Application No: BR/13/22/HH
Site Address: 235 Hawthorn Road Bognor Regis PO21 2UW
Description of works: Erection of two storey side extension and single storey rear orangery following the demolition of existing rear conservatory and side extension.

Thank you for your internet representation made on 16th February 2022 which has been recorded as an objection with the comments as follows:

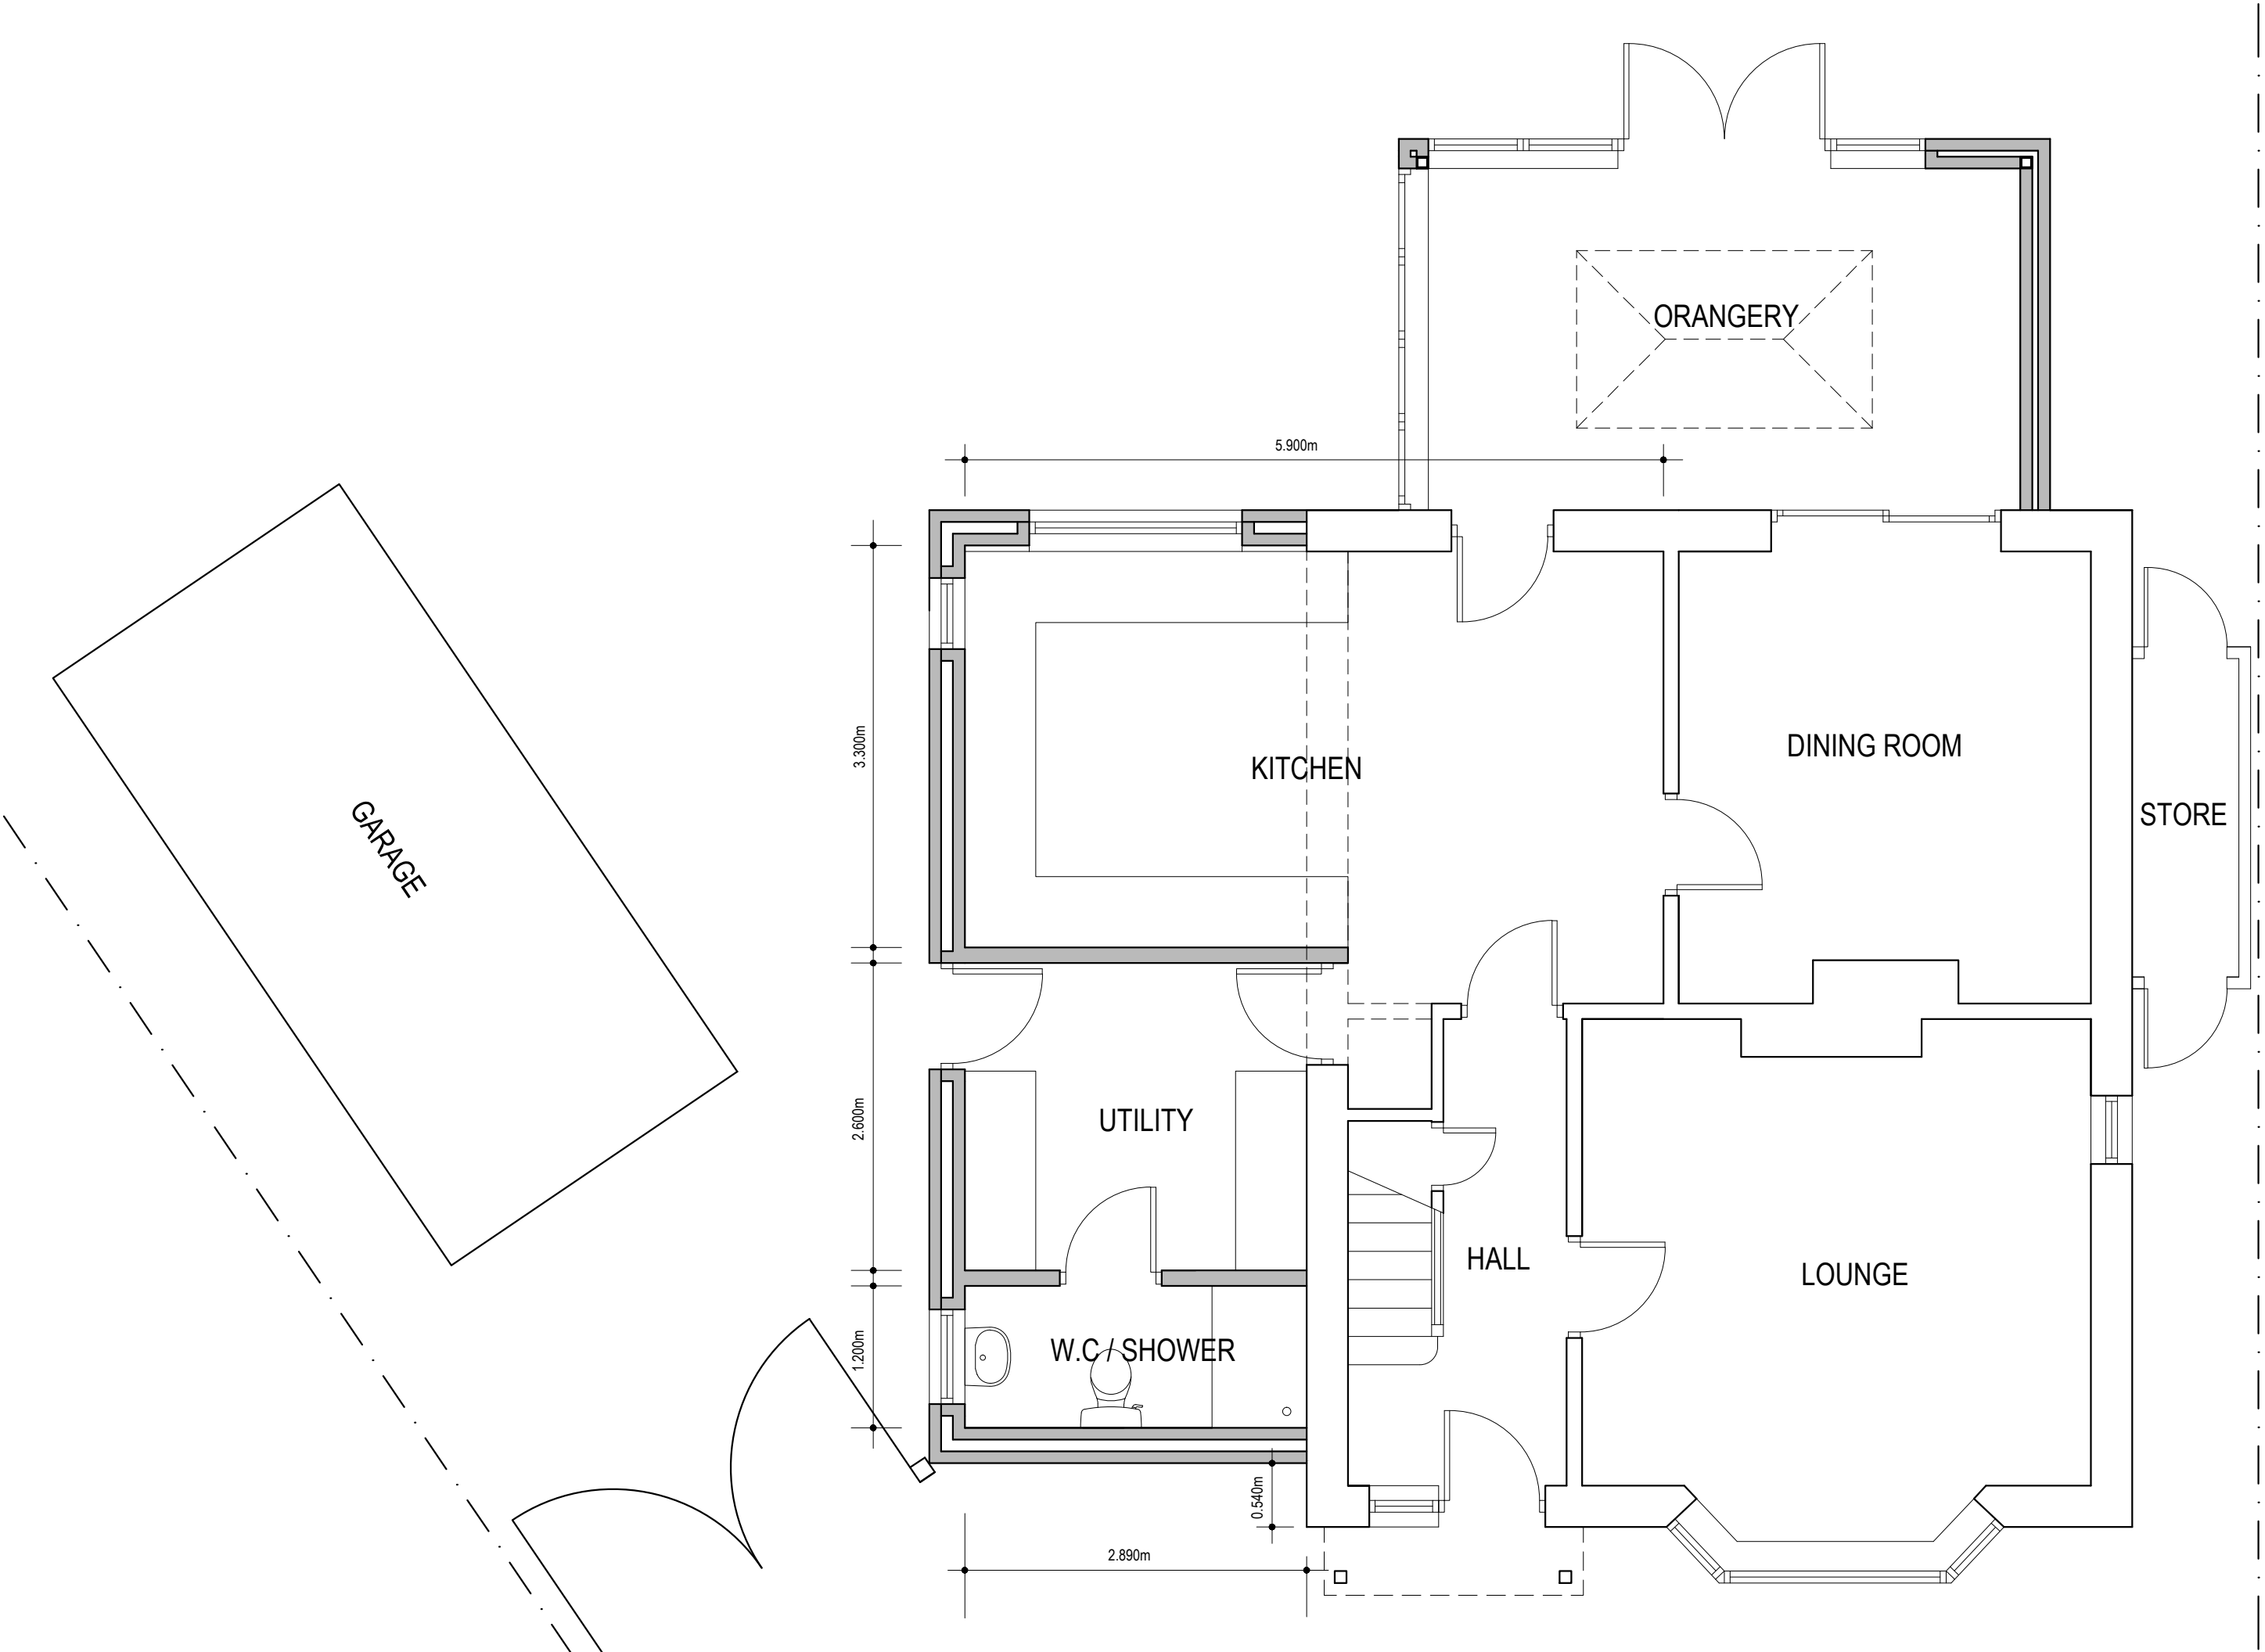
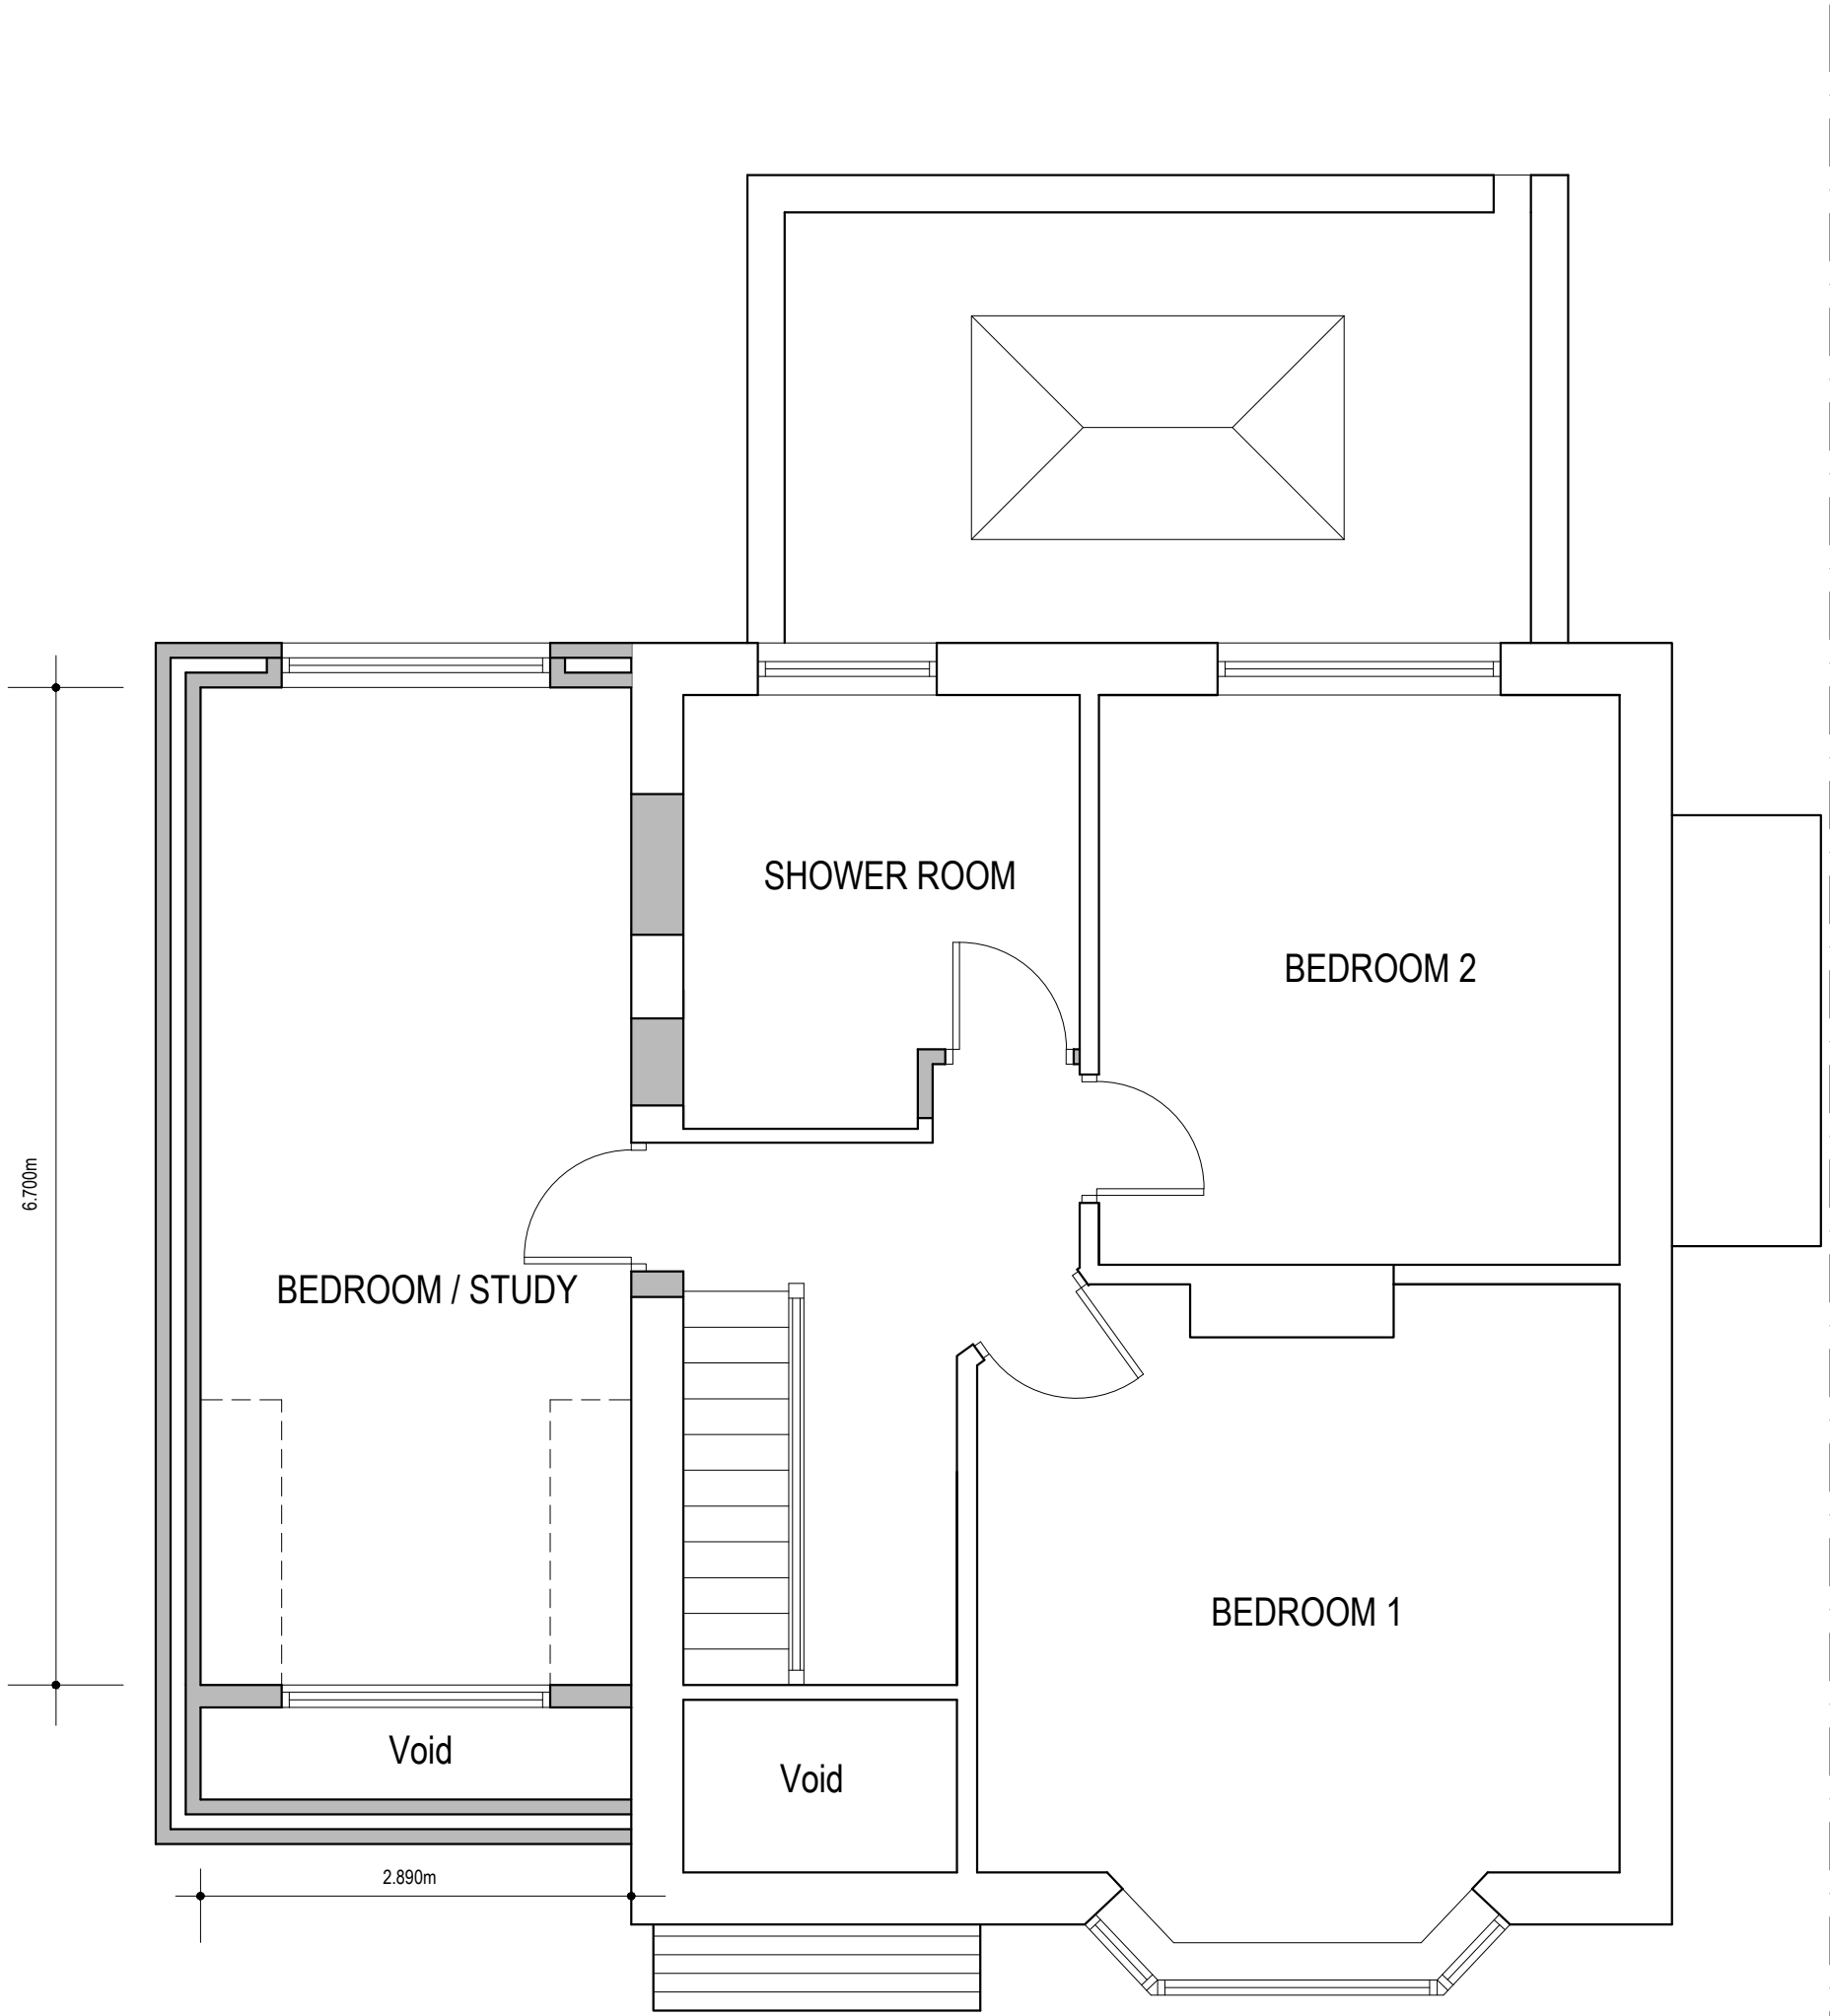
- 1) At present from our property, the first floor rear window at the rear is mostly obscured by our trees and shrubs. The three first floor side elevation windows have obscure glass so do not effect our privacy. The new side extension, however, would appear to be some one third the width of the existing property, bringing it closer to our boundary and although the middle window would probably have obscure glass fitted, the additional large first story window would not and would directly overlook our property, considerably reducing our privacy.
- 2) The height and width of the additional one third extension would result in our losing late afternoon sunshine in summertime.
